**ANGEL PLACE
LEVEL 8, 123 PITT STREET
SYDNEY NSW 2000**

WATERLOO METRO QUARTER - SOUTHERN PRECINCT SSD DA (SSD-10437) | RESPONSE TO REQUEST FOR FURTHER INFORMATION

### 16. Parapet

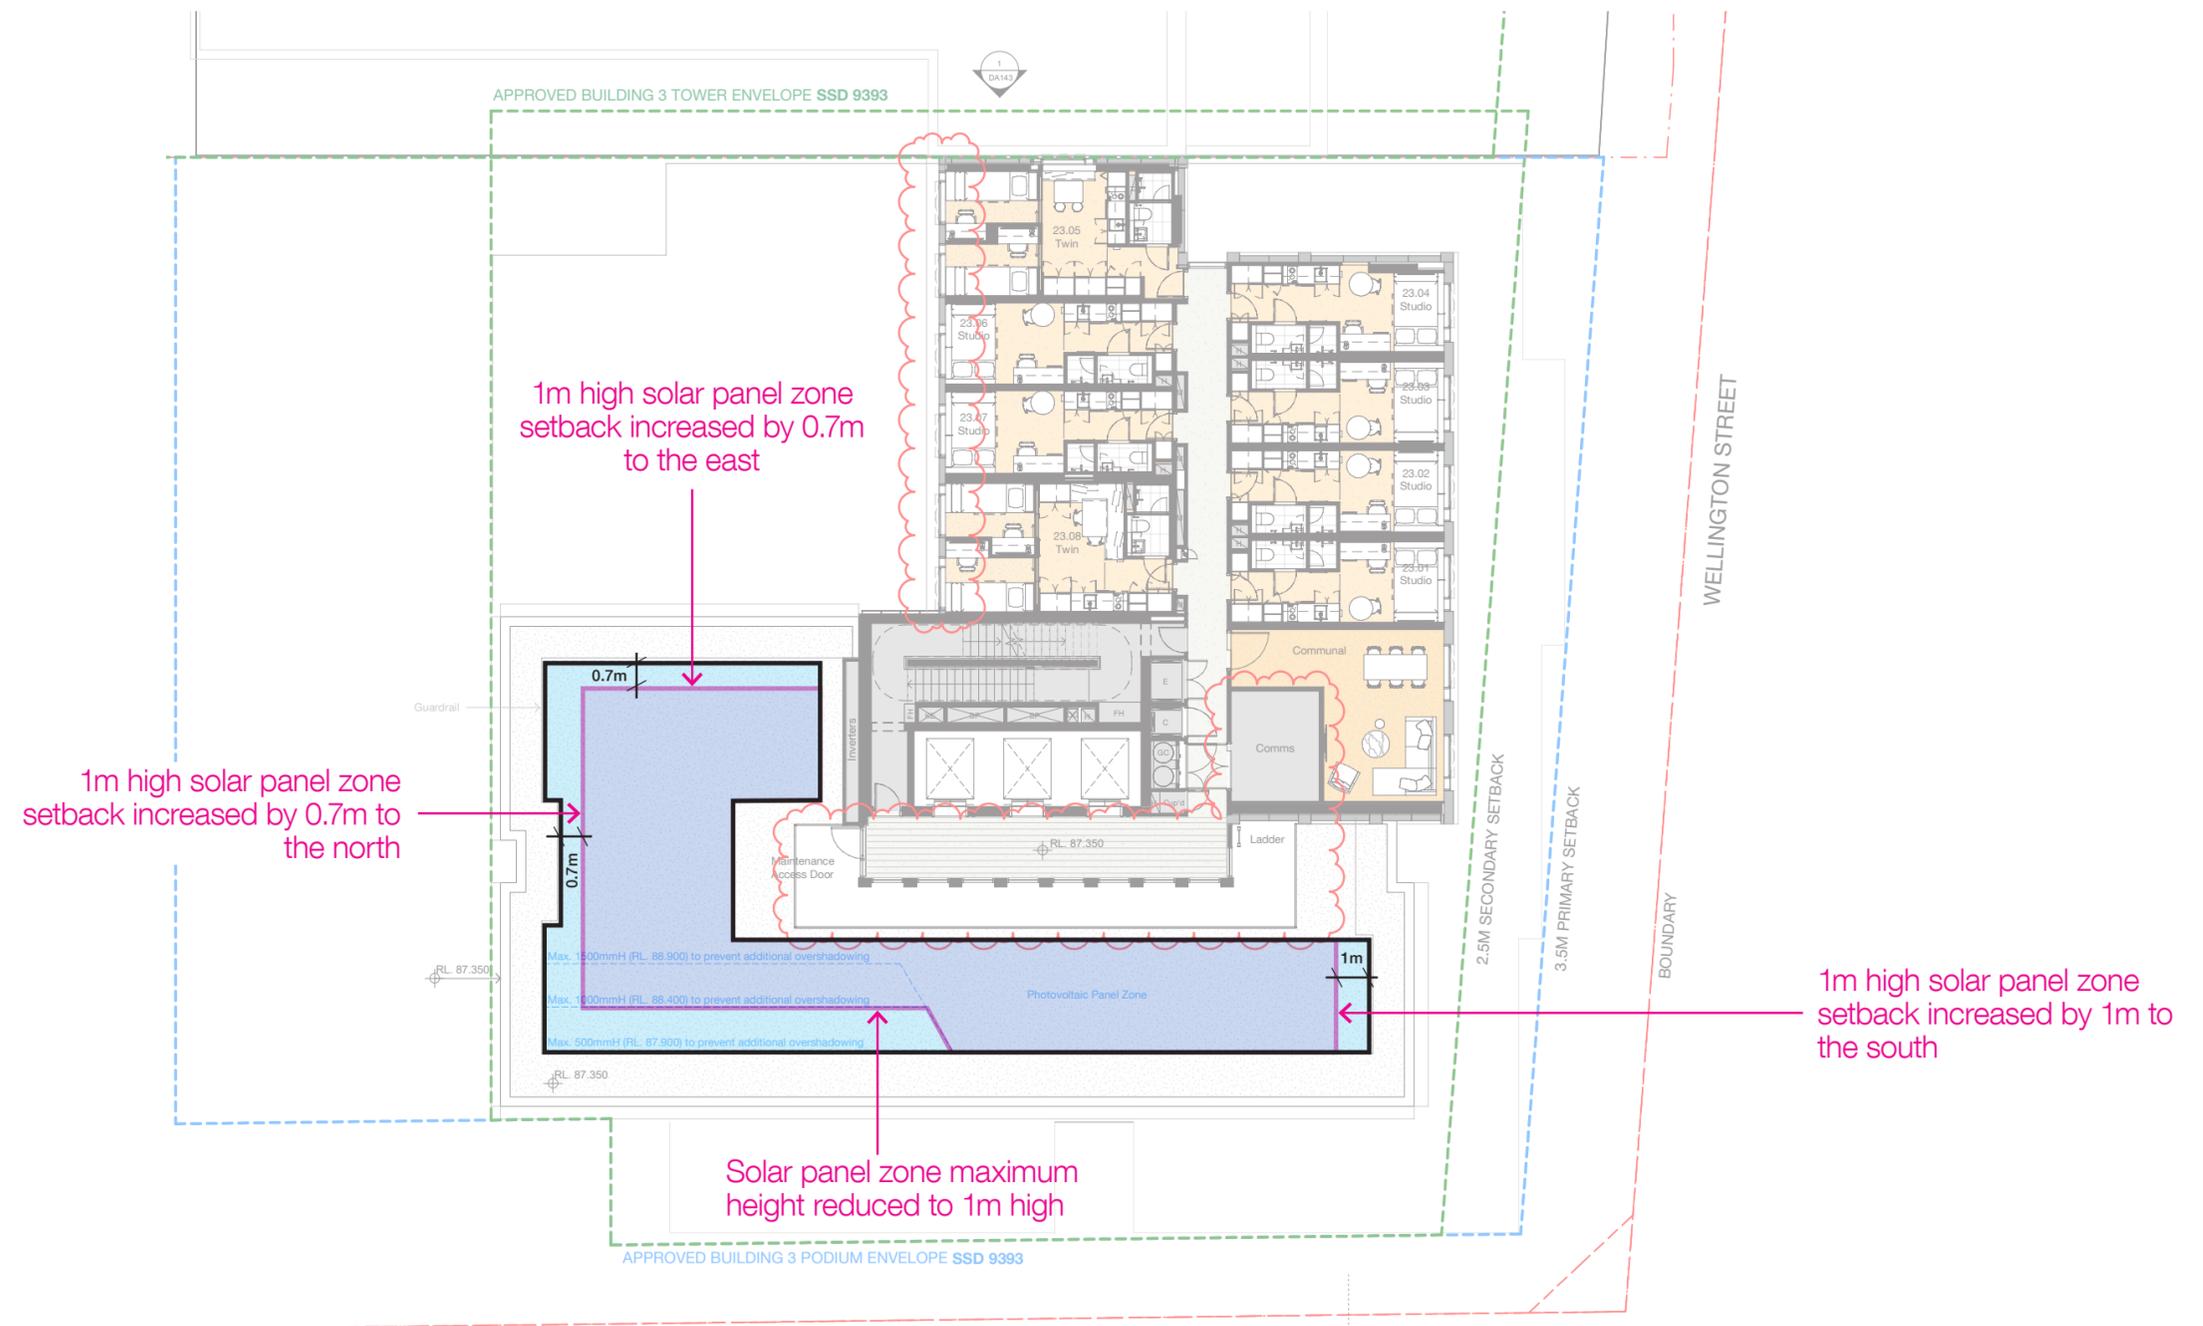
Council have requested that the height of the parapet on Buildings 3 and 4 is increased to screen any plant and services equipment.

As outlined in the Architectural Design Memo prepared by Bates Smart at **Attachment A**, the proposed increase to the parapet height for both Buildings 3 and 4 is not deemed acceptable for the following reasons:

- In accordance with the Design and Amenity Guidelines, the development must not result in any additional overshadowing of Alexandria Park after 10am on 21 June and no more than 30% of Alexandria Park excluding the oval is overshadowed by the development as measured at any time after 9am on 21 June. The current proposal satisfies this design criteria.

- A lengthy and detailed design process was undertaken during the preparation of the development application to ensure minimal overshadowing from the proposed development to Alexandria Park. Various amendments were made to the detailed design to ensure the proposed scheme resulted in less overshadowing than the approved envelope. Increasing the parapet height for Building 3 will increase overshadowing to Alexandria Park and is not considered appropriate.

- To mitigate visibility from the surrounding area, the maximum height of the solar panel zone is proposed to be reduced from 1.5 metres to 1 metre and limited to 500mm high at the edge of the building to the north, south and east. The setbacks from the edge of the building to the solar panel zone is proposed to be increased to the north, south and east. It is requested that a condition of consent be imposed requiring these changes be made to the solar panel zone.

### 20. Materials

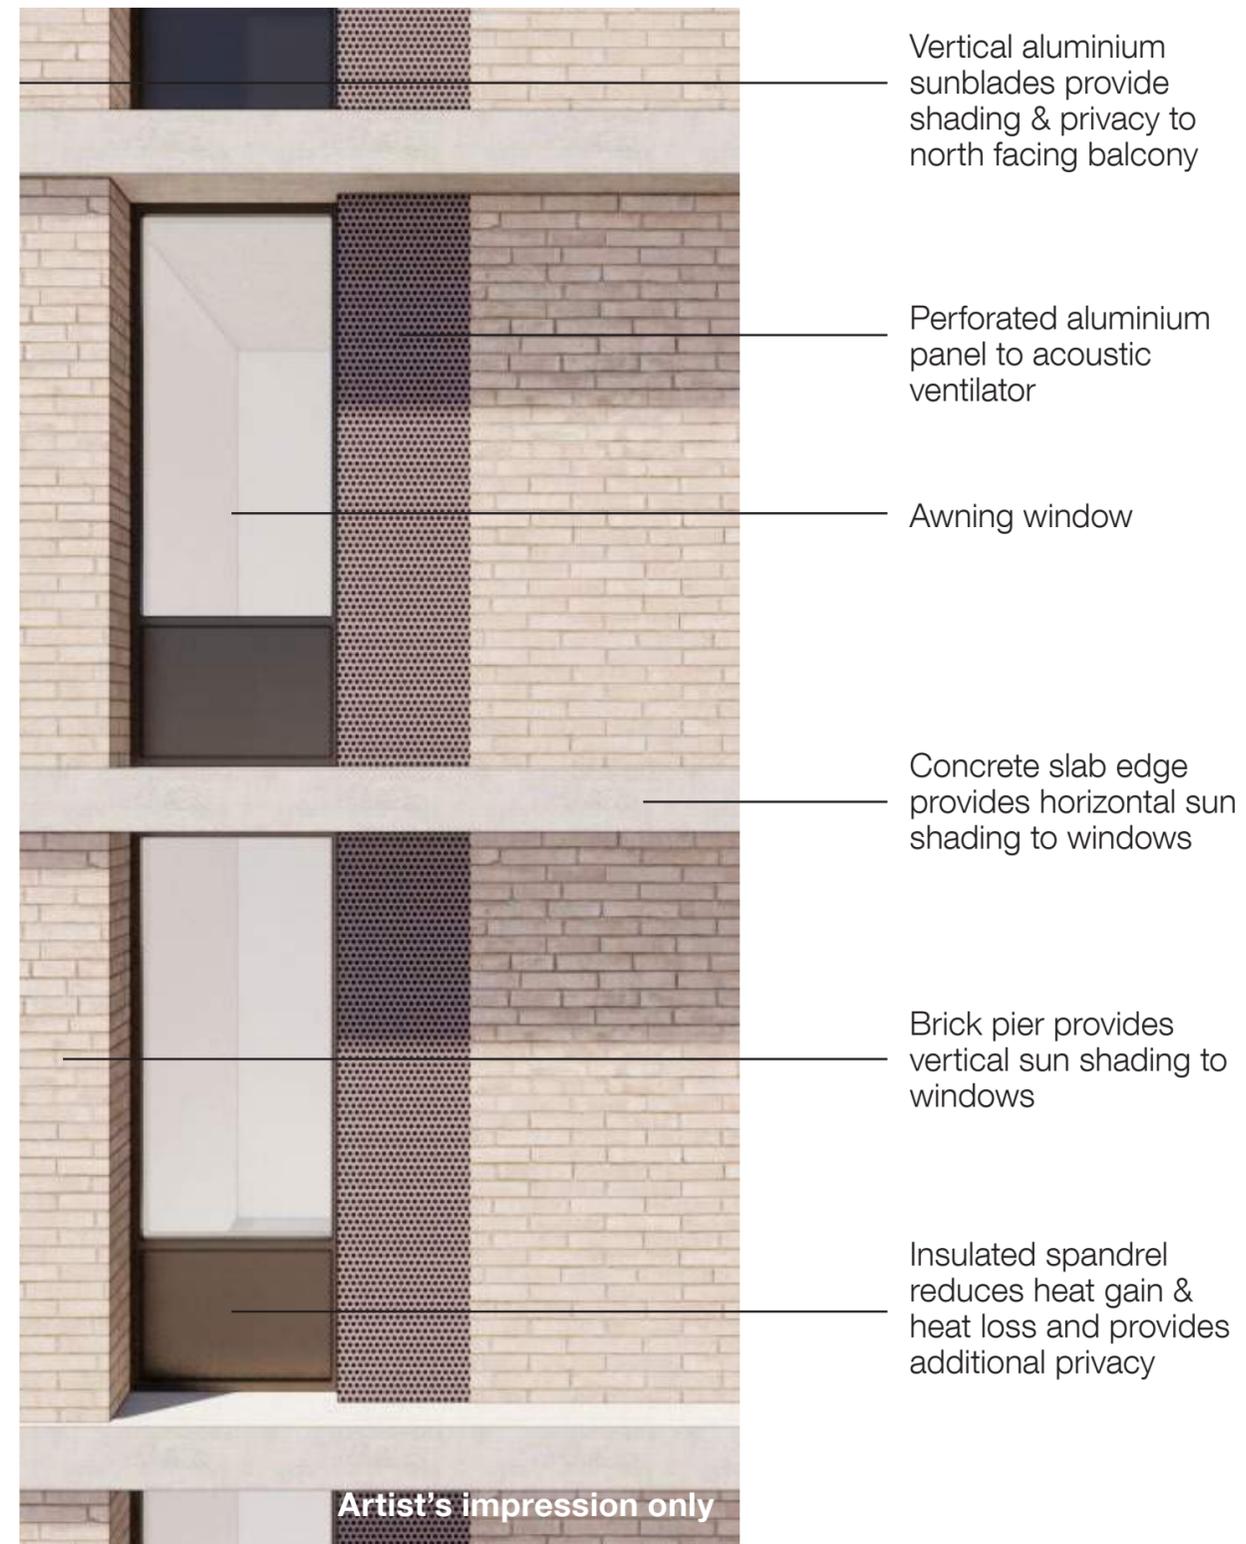
- The glazing does not appear to be clear and untinted. High performance and heavy tinted glazing are not a good urban design outcome, and
- Awning windows provide substandard amenity for occupants by minimising airflow. Sashes or casement windows should be provided instead of the awning windows.

Awning windows are proposed as they enable occupants to open their windows and experience natural ventilation, whilst maintaining weather protection. A casement or sash window does not provide the same level of weather protection.

Sashes (double hung) windows are proposed to the western elevation where the windows are situated behind vertical louvres, and the operation of an awning window is not possible.

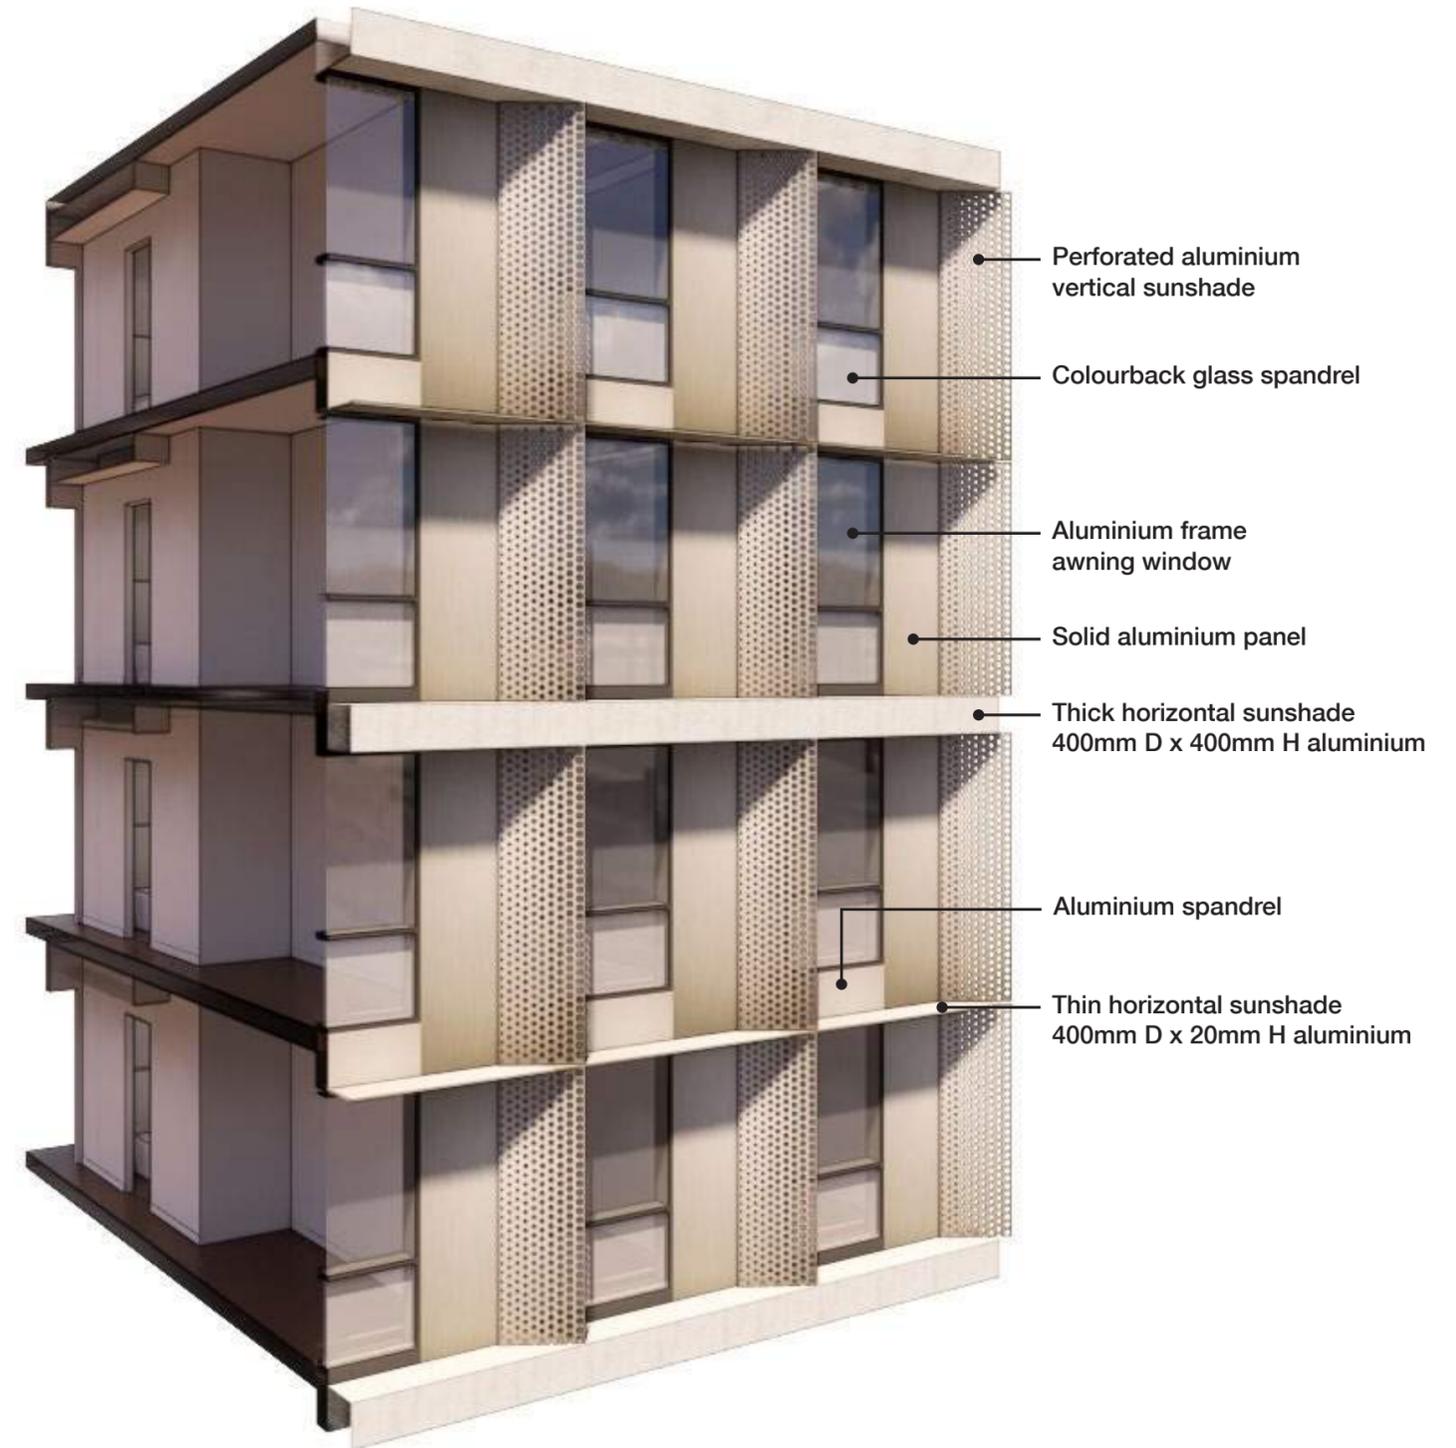
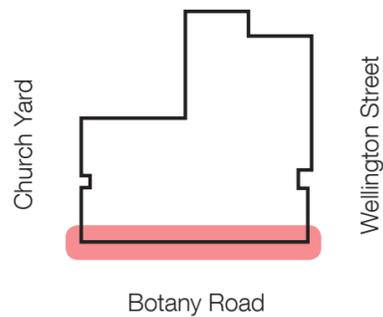
Council have raised concerns with the solar access and external shading provisions for Buildings 3 and 4.

With regards to Building 3, the design of the western elevation has been developed through the DRP process to create a highly articulated facade that responds to the western sun. Individually operable shading devices were considered by the design team, however, they were deemed not practically viable for student accommodation due to ongoing maintenance and management issues. Fixed shading was therefore considered to be a more functional and suitable shading solution.

The solar and thermal performance of the Building 3 western facade was addressed during DRP no. 13 following comments raised in the RTS report. At the DRP meeting it was demonstrated that the inclusion of both vertical and horizontal shading elements contributed to a 45% reduction in solar gain

to windows during the summer months. It is also noted that the facade has a high degree of solidarity which benefits thermal performance. The 'Summernox' (the average of summer solstice and equinox) was considered to be an appropriate method of demonstrating the average efficacy over the full period of summer. The current proposed design was therefore supported by the DRP.
